FROM: Margaret Haynes, NMDOT Assistant District 3 Traffic Engineer

SUBJECT: QT 7001 Traffic Impact Study  
Southwest Quadrant of Unser Blvd. and Los Volcanes south of I-40  
Albuquerque, New Mexico

The NMDOT received the QT 7001 Traffic Impact Analysis July 2024. District Three's comments are below.

SHEET TITLE:
SITE PLAN

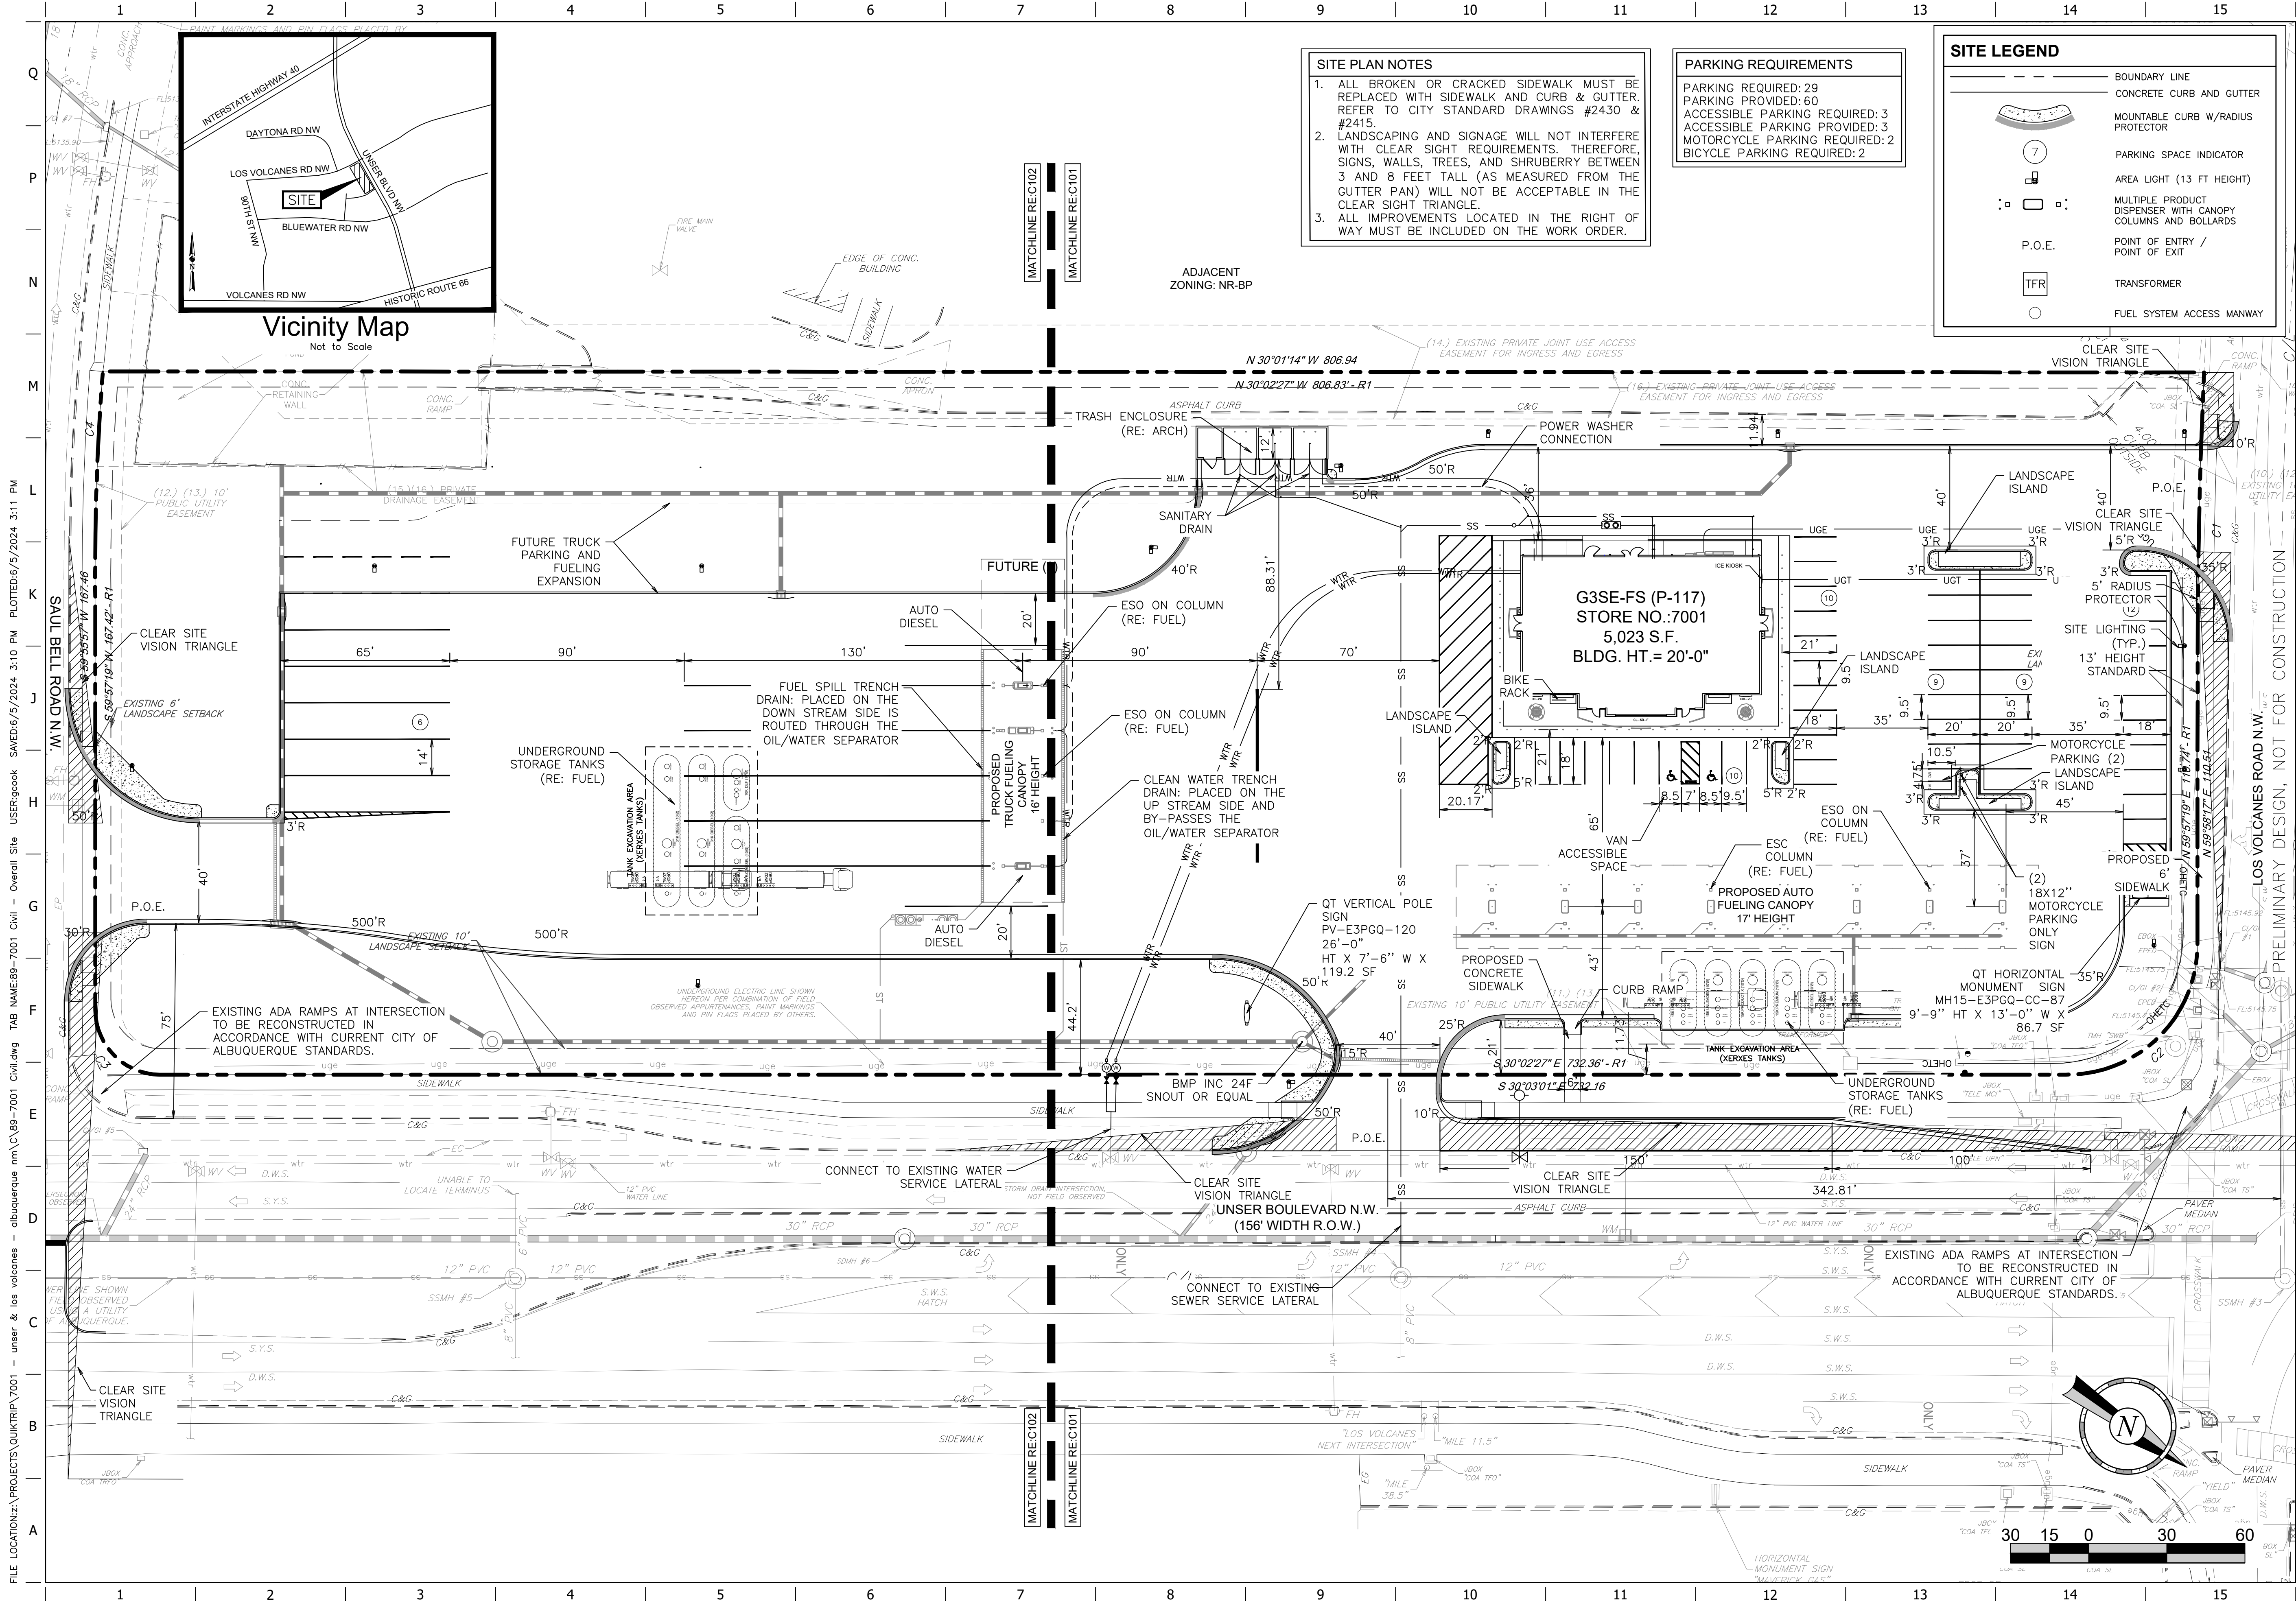
Page 9 – Please label access points on site plan.

Page 27 – Many arguments have been made about mixing heavy trucks and passenger vehicles to justify additional access points. Here it seems all are using Driveway 1. Please provide site circulation plan for each access.

Page 28 – When compliant deceleration lane design cannot be achieved, then access locations should be optimized or eliminated.
